Appeal Decision

Appeal Ref: APP/R5510/D/24/3345547

112 Swakeleys Road, Ickenham, Hillingdon UB10 8BA

- The appeal is made under section 78 of the Town and Country Planning Act 1990 (as amended) against a refusal to grant planning permission.
- The appeal is made by Mr A Garg against the decision of the Council of the London Borough of Hillingdon.
- The application Ref is 41605/APP/2024/302.
- The development proposed is described as 'to increase side dormers by 2m'.

PROPOSAL TO INCREASE SIDE DORMERS BY 2M ON EITHER SIDE OF THE PROPERTY

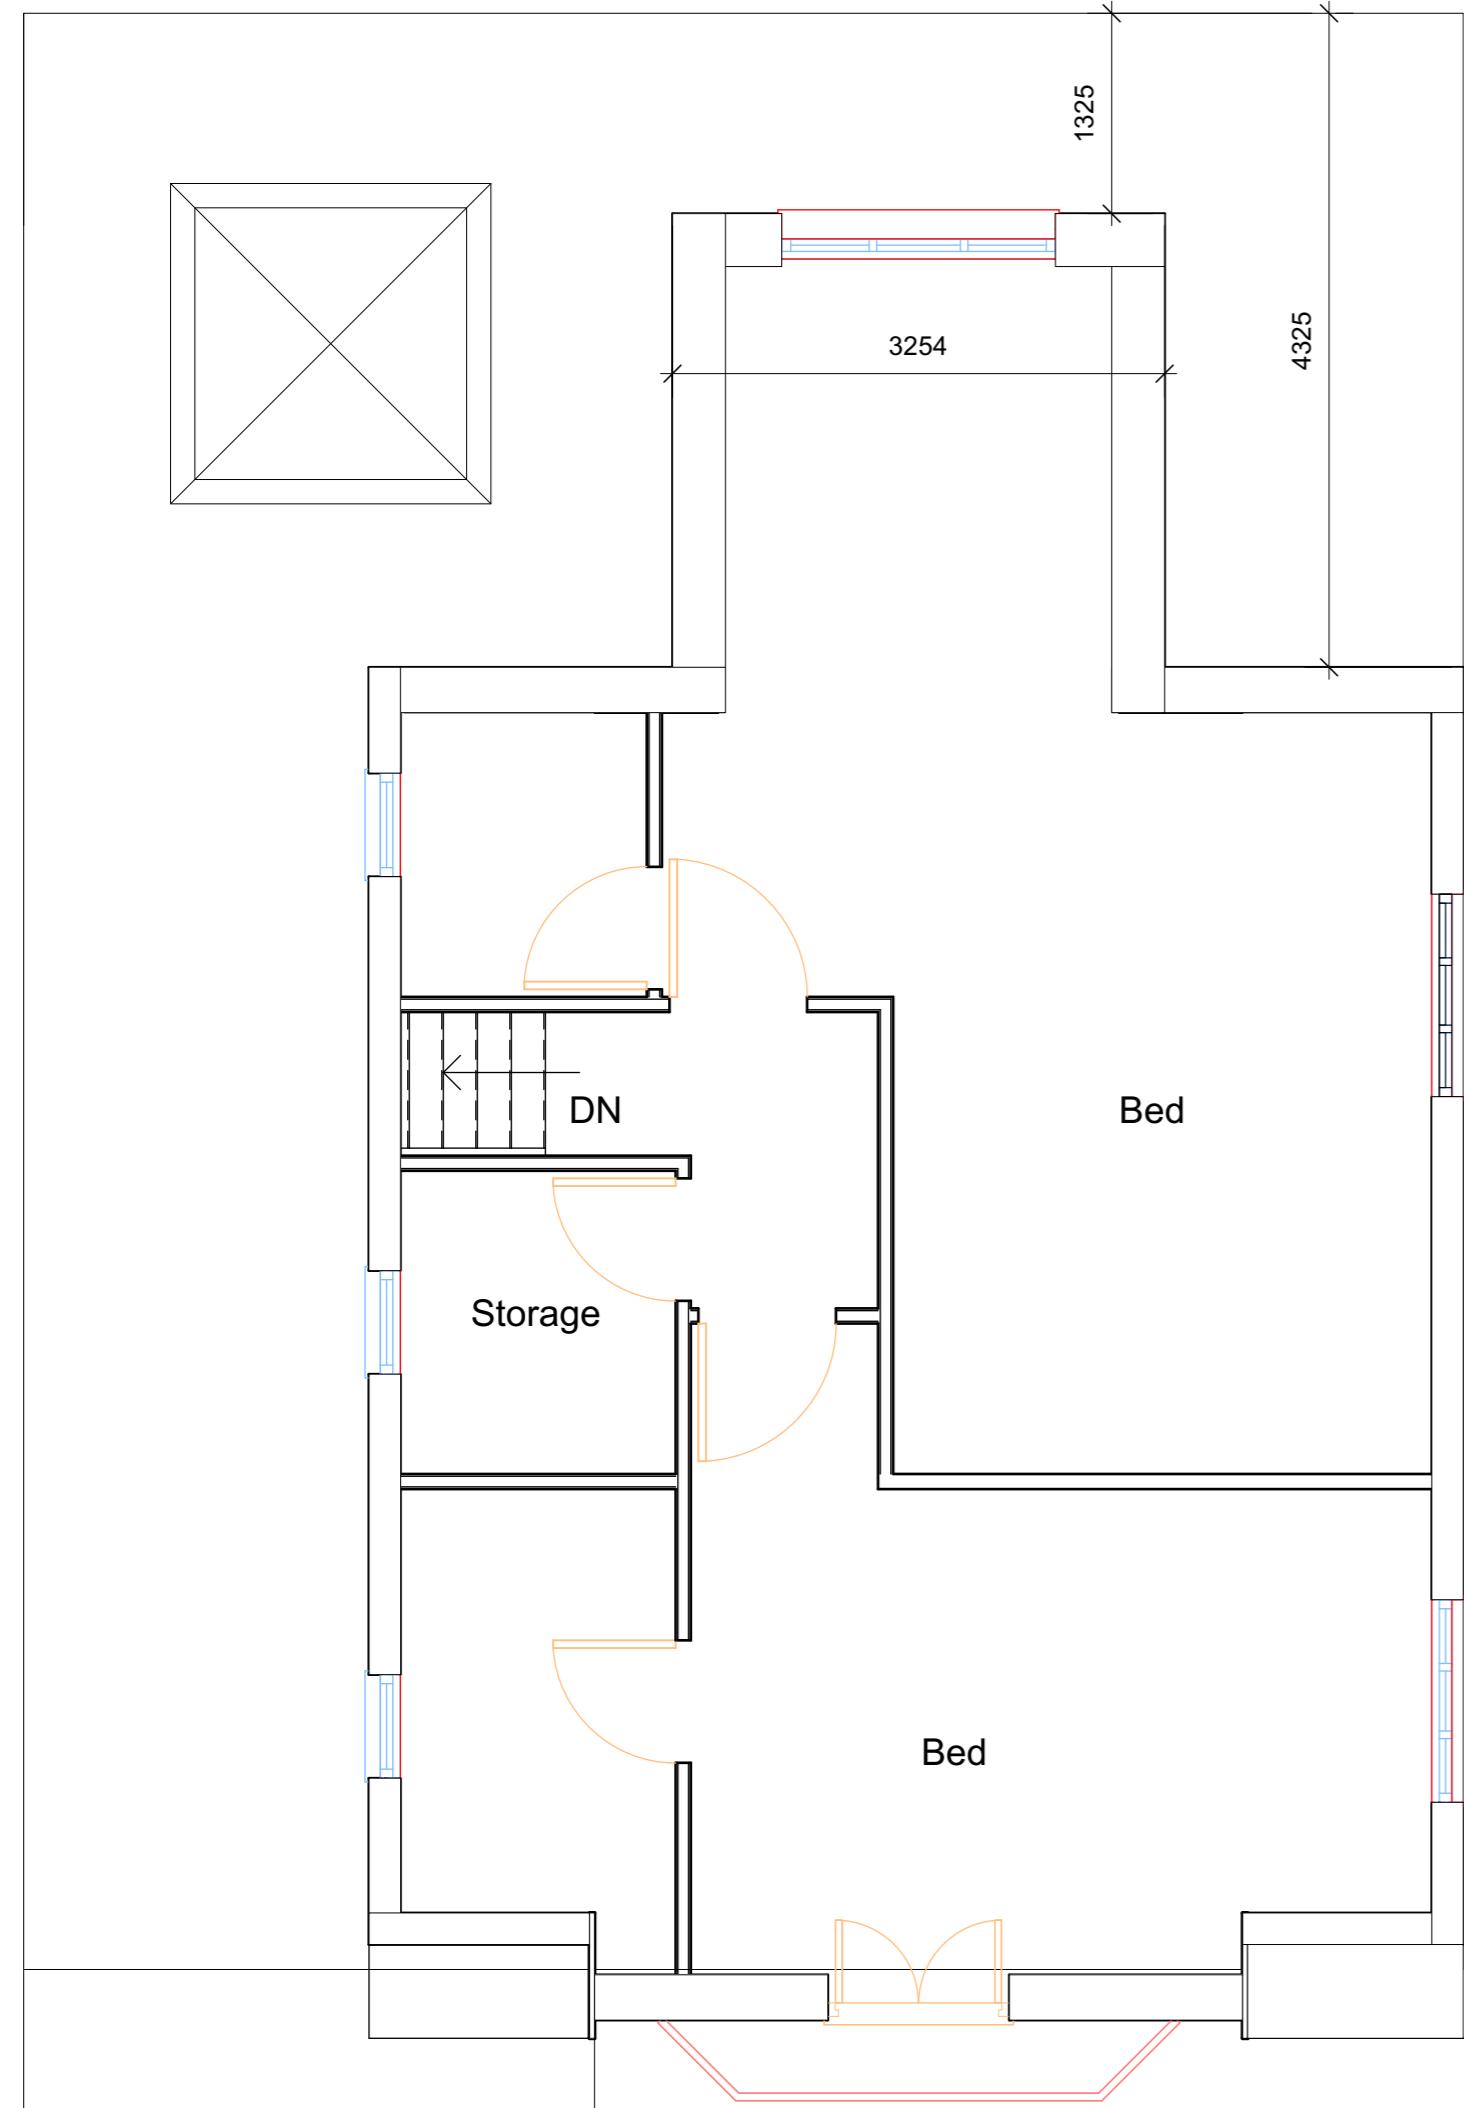
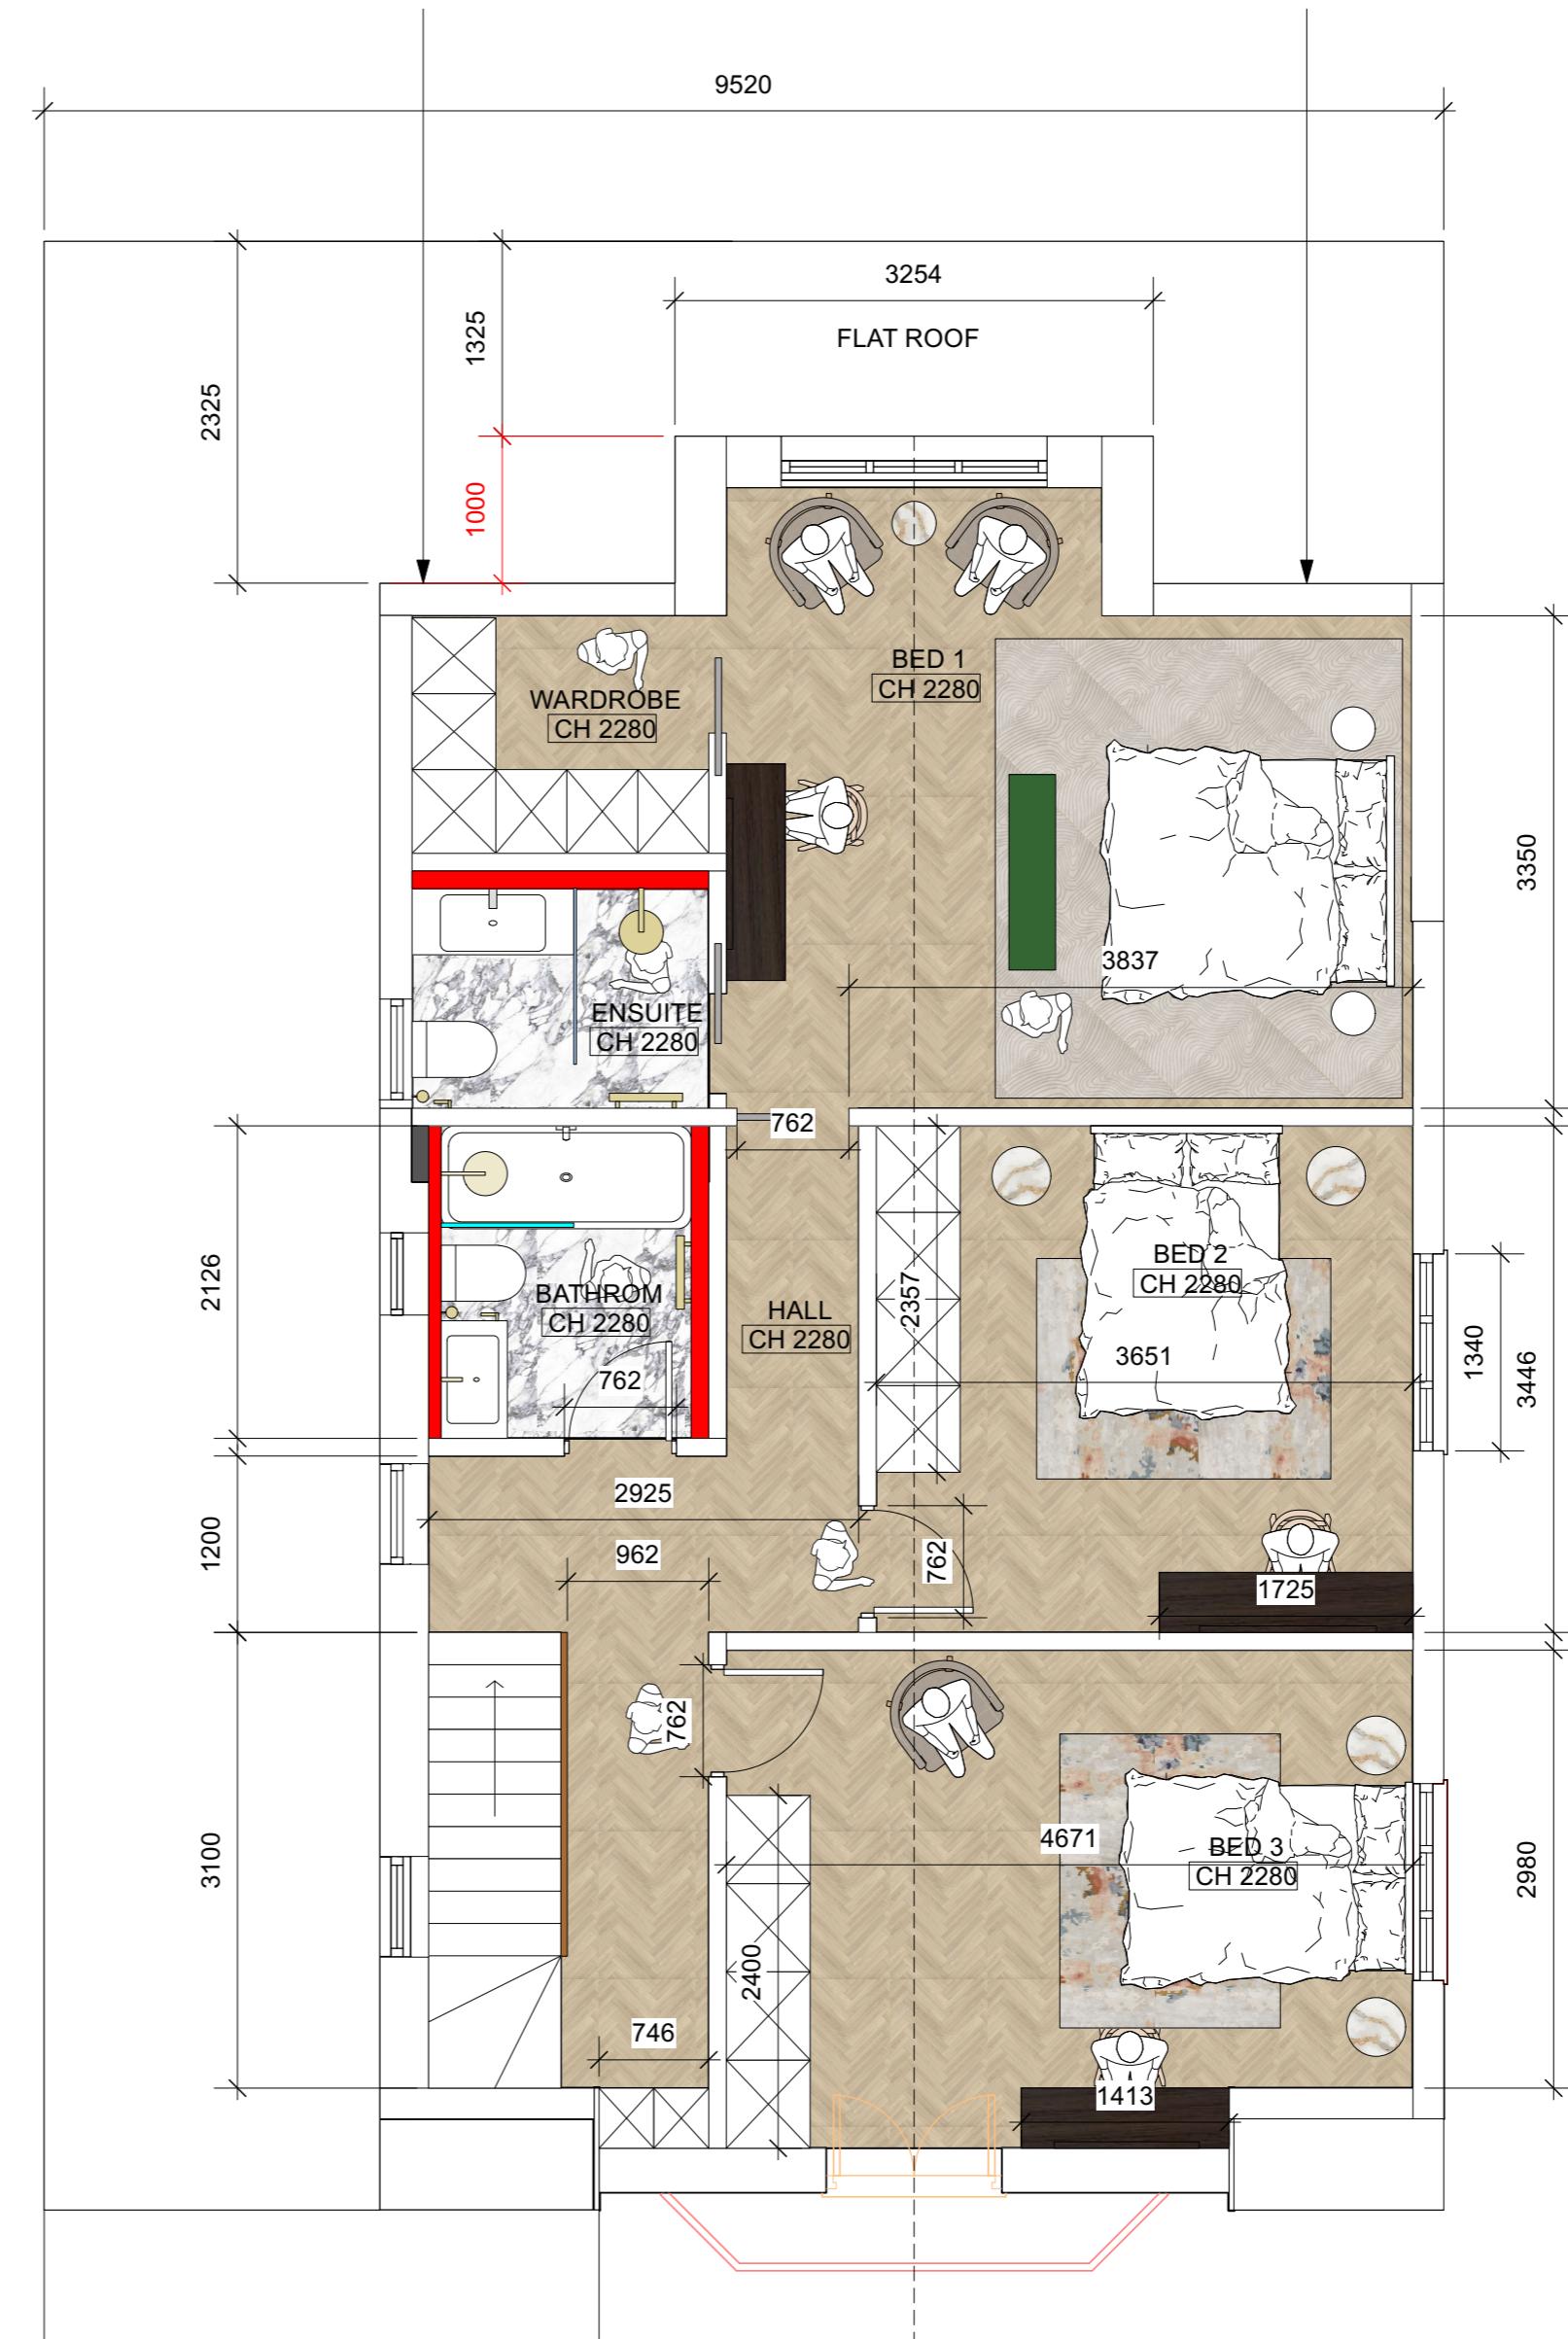
5. The extended dormers would be located below the ridge tiles, an element of the original and extended roof slopes above the eaves line would be retained and they would be set in 1m from the rear elevation of the first-floor extension. The dormers would therefore remain within the roof profiles. The additional length of the dormers would be proportionate to the size of those that have previously been approved and would be proportionate to the bungalow as it would be extended. The larger dormers would be sufficiently subservient to the scale of the existing roof.
